DECISION DELEGATED TO HEAD OF PLANNING

Application No:	H16-0101-22	Applicant:	The Lighthouse Church
Proposal:	Demolition of rear hall and erection of two storey extension to incorporate ground and first floor halls, kitchen, food bank and function rooms.		
Location:	10 Haverfield Road Spalding		
Terminal Date:	10th June 2022

PROPOSED FIRST FLOOR PLAN

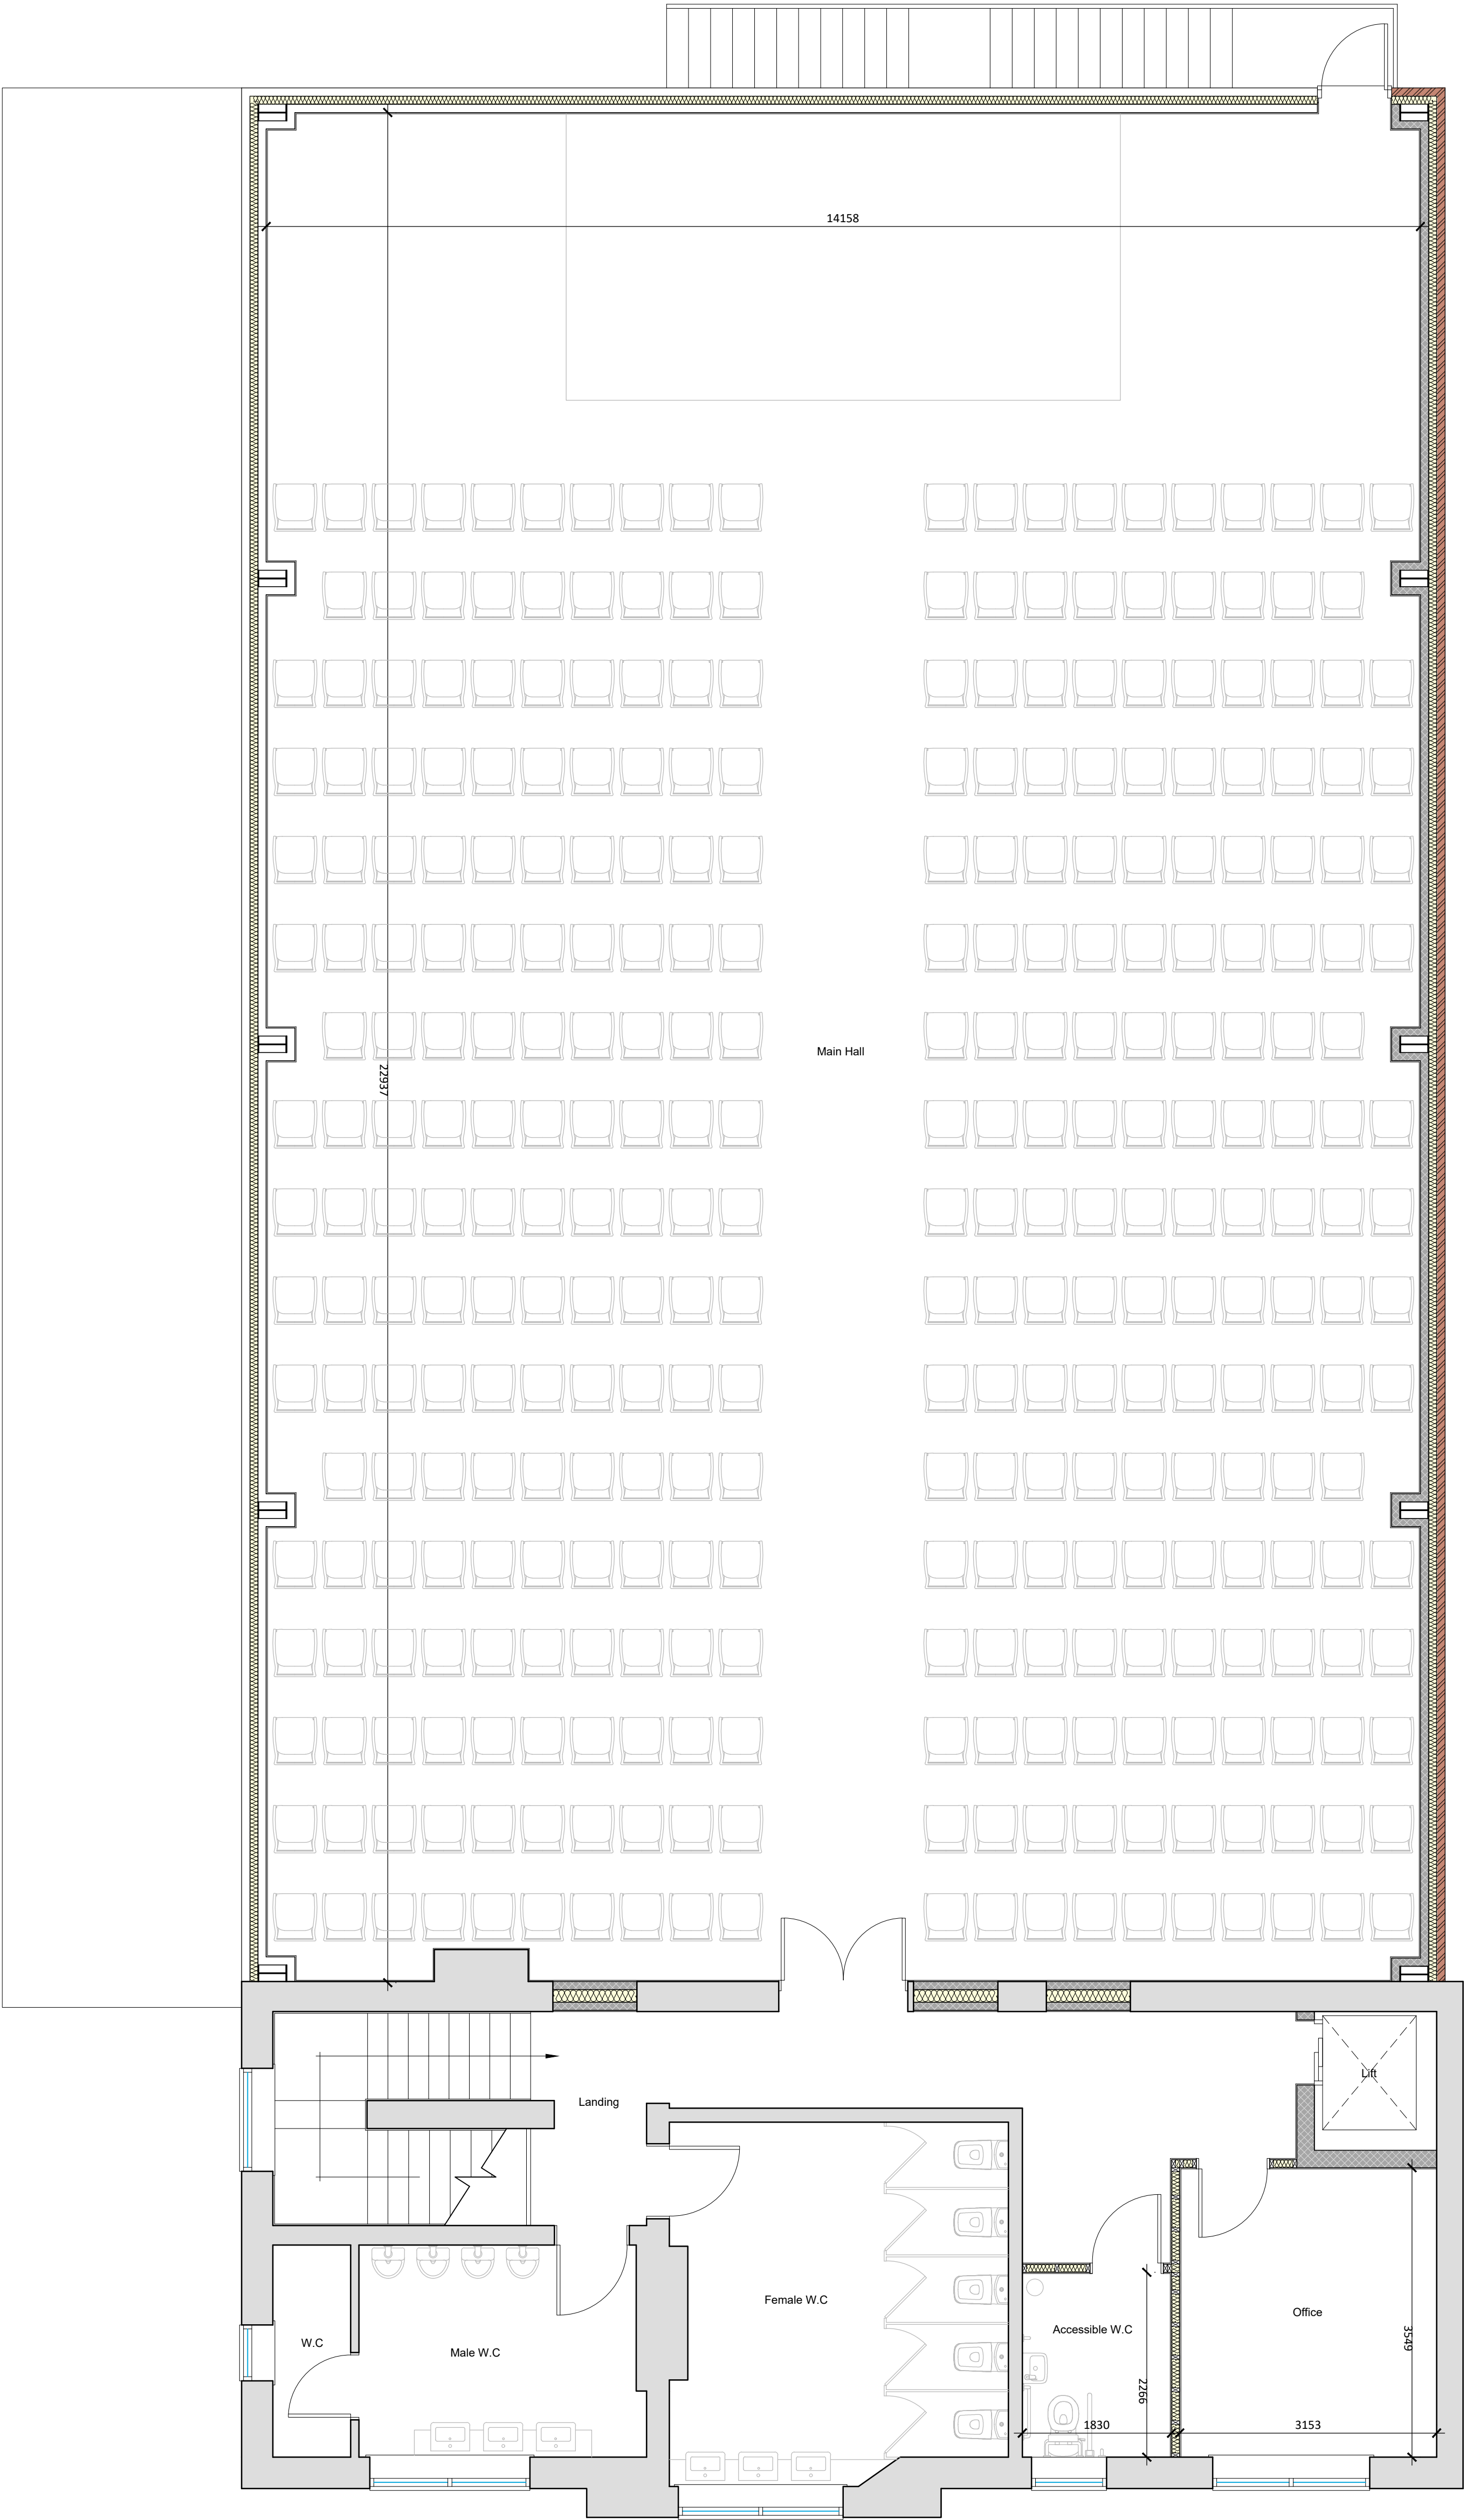
The proposed first floor extension will accommodate a new main hall to the first floor measuring approx. 22.9m by 17m. A new fire exit with a staircase will be formed from the first floor and will be situated on the rear elevation. The first floor extension covers the entire footprint of the existing ground floor. As well as the first floor extension, there is also a ground floor side extension extending out approx. 2.9m by 23m.

There are no windows proposed to the first floor extension. There were public comments made about the external staircase in terms of concern regarding overlooking, however, the staircase is for fire escape purposes only and would not cause a material issue as this would only be used in case of an emergency. It is therefore considered that the proposed extension would not have an adverse overlooking impact on adjacent dwellings.

DRAWING: PROPOSED ELEVATIONS

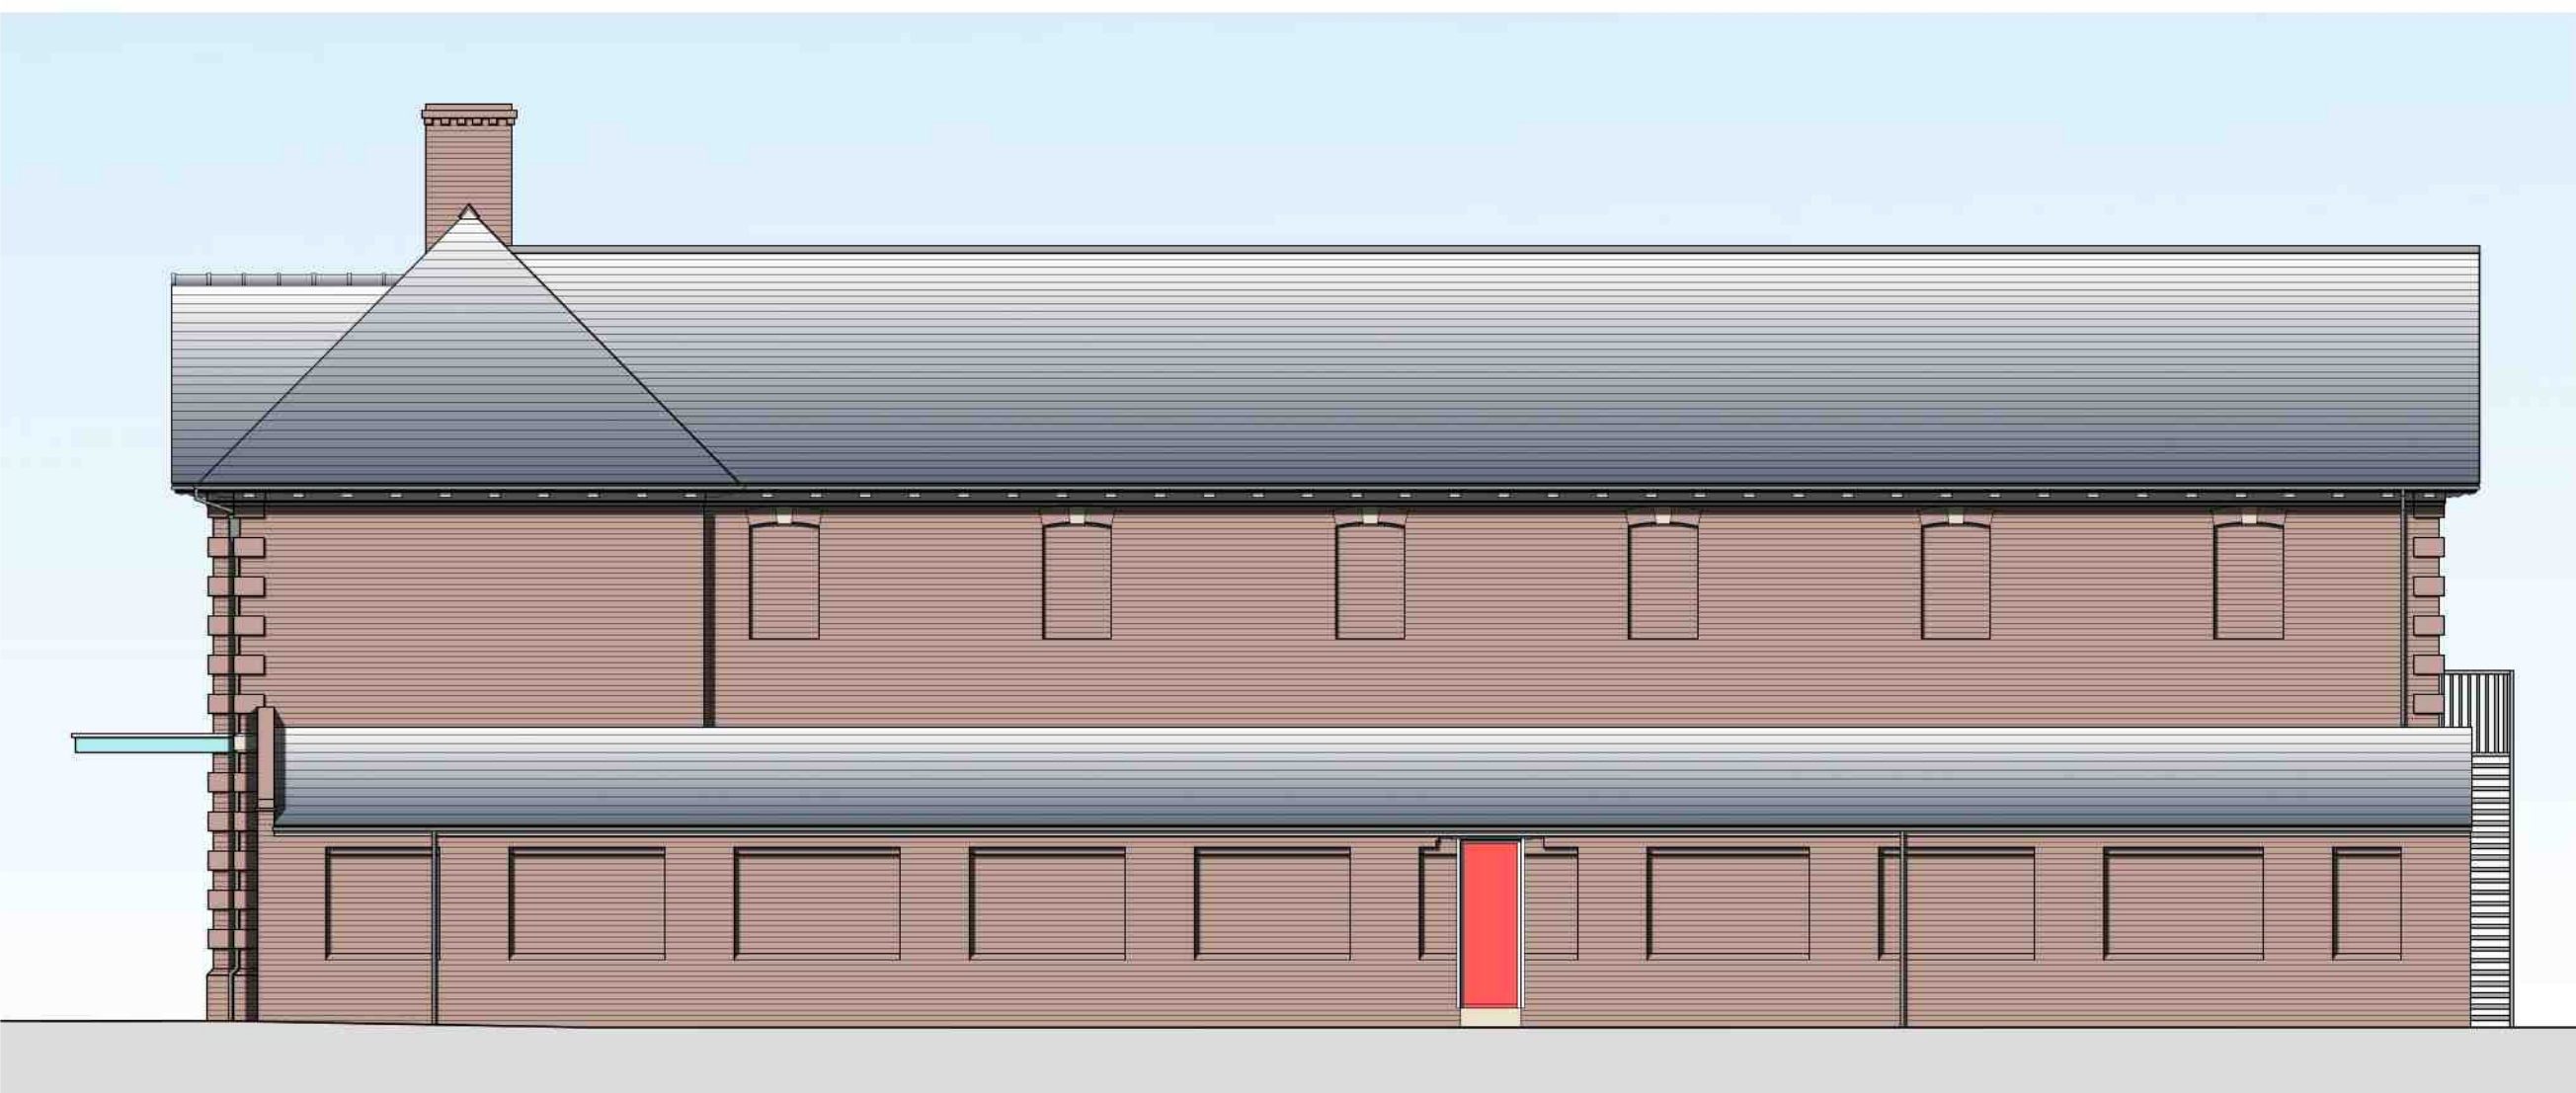
The proposed extension to the Lighthouse Church is considerable in terms of scale. The first floor extension would not include any windows, therefore there are significant areas of blank walling. Even though the church is not a listed building, it is considered to be a building with historic merit to the Spalding Conservation Area, and with the use of taxation windows to the exterior side elevations of the first floor, this is considered to add interest and further features to compliment with the existing structure.
